**Consultation Response from KC,
Highways Development Management**
2021/91678 Robertos, The Old Post Office, 15, Market Square, Batley, WF17 5DA
Erection of canopy (within a Conservation Area)
Date Responded: 25/08/21 Responding Officer: CNB Responding Ref: K13-10SW/12

Plan

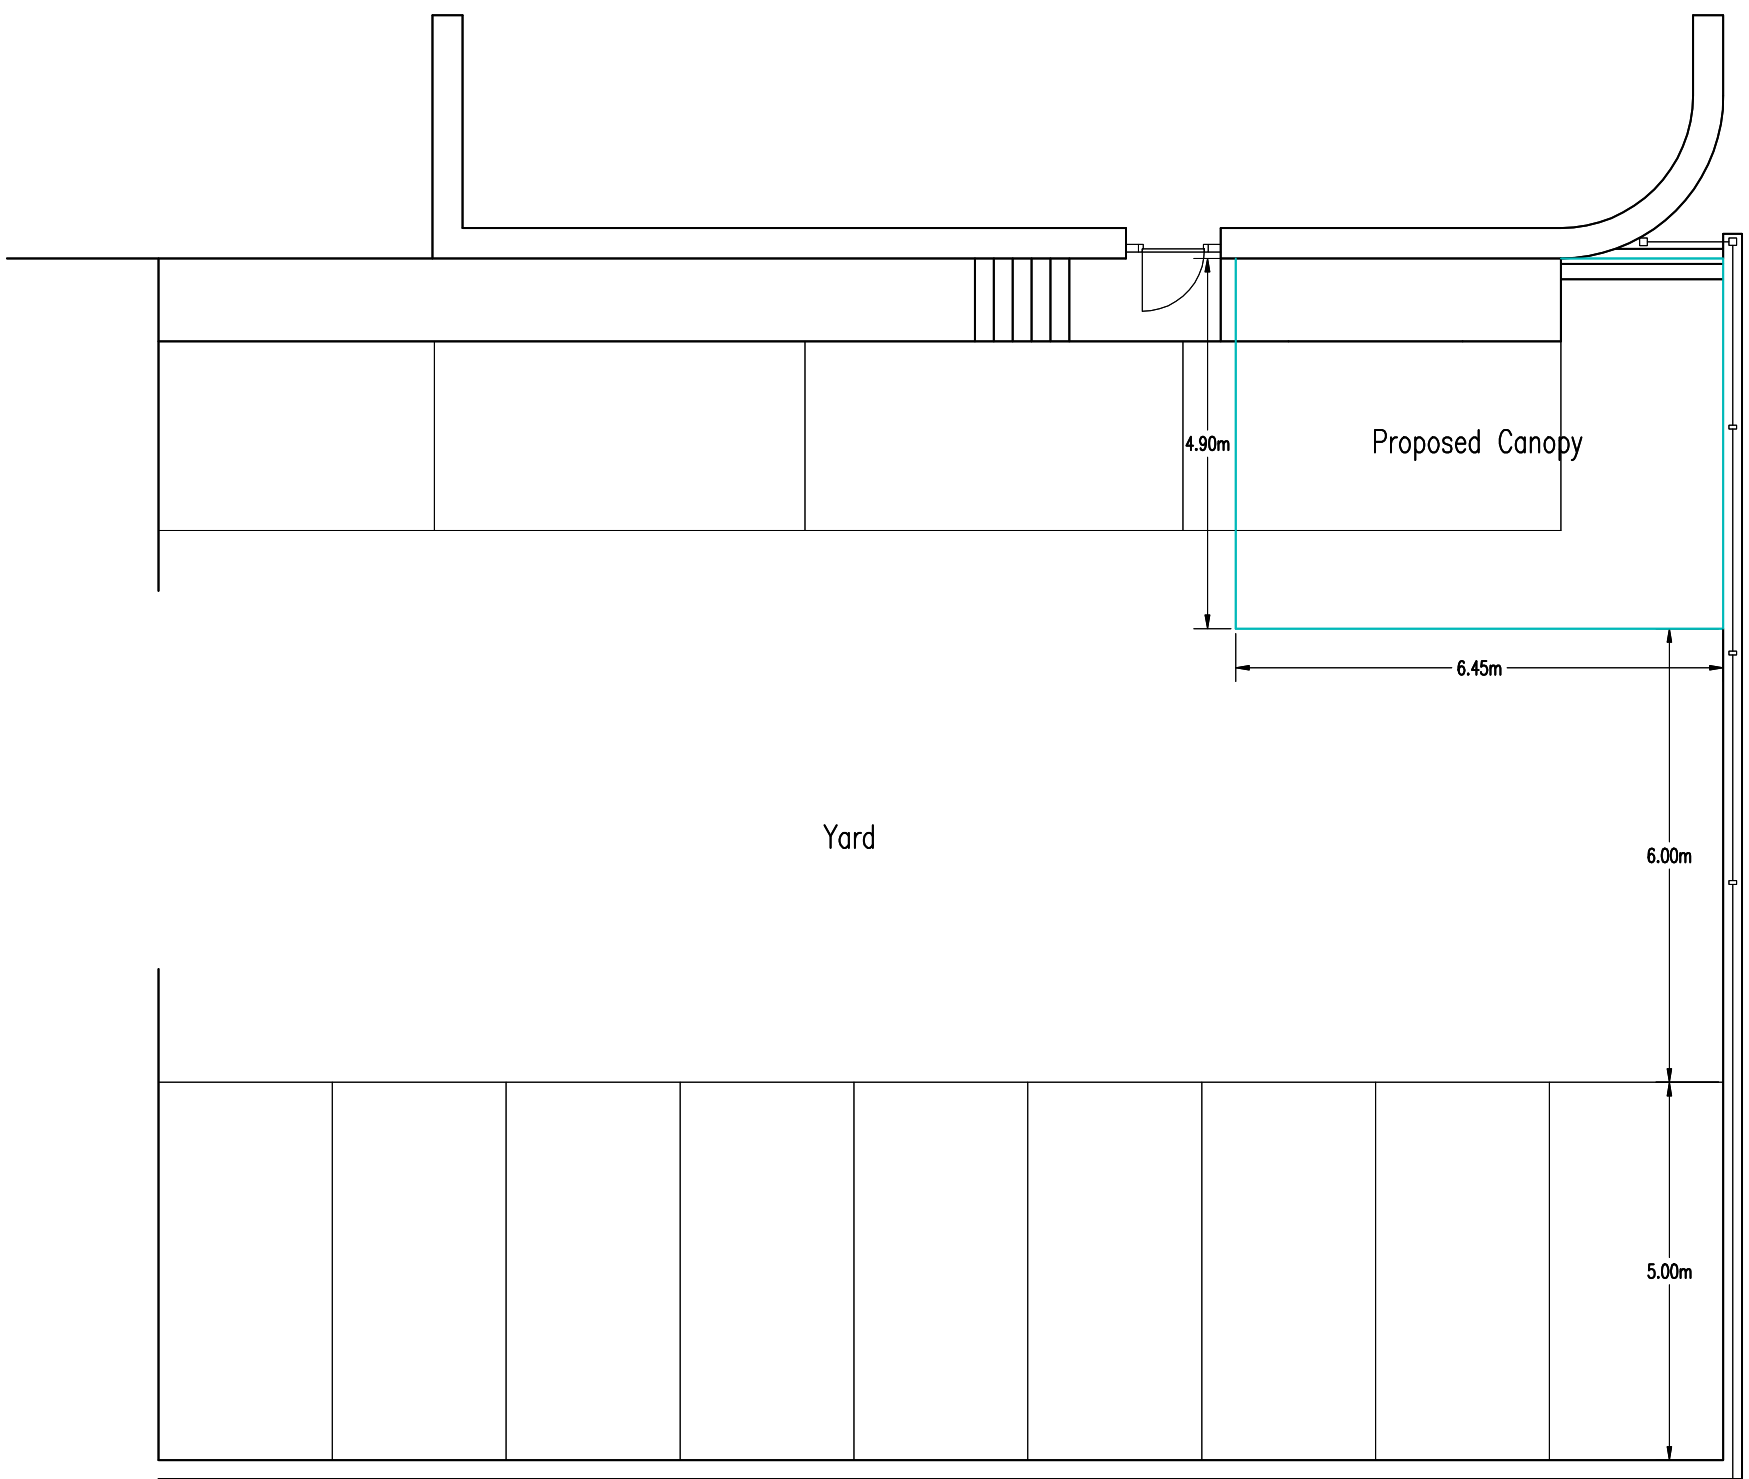
The location of the proposed canopy and balustrade is over one of the marked spaces within the car park and as such this space will be lost (the application form erroneously states that there will be no changes to car parking). It is also possible that a second space will become unusable as, although there will be a 6m gap between the south westernmost parking space, we suspect that manoeuvring from this space will be limited by the proposals if there are cars parked adjacent. However, as the site is located in the town centre of Batley with access to public car parks and the public transport network (the site is approximately 225m from the bus station and approximately 950m from the rail station).
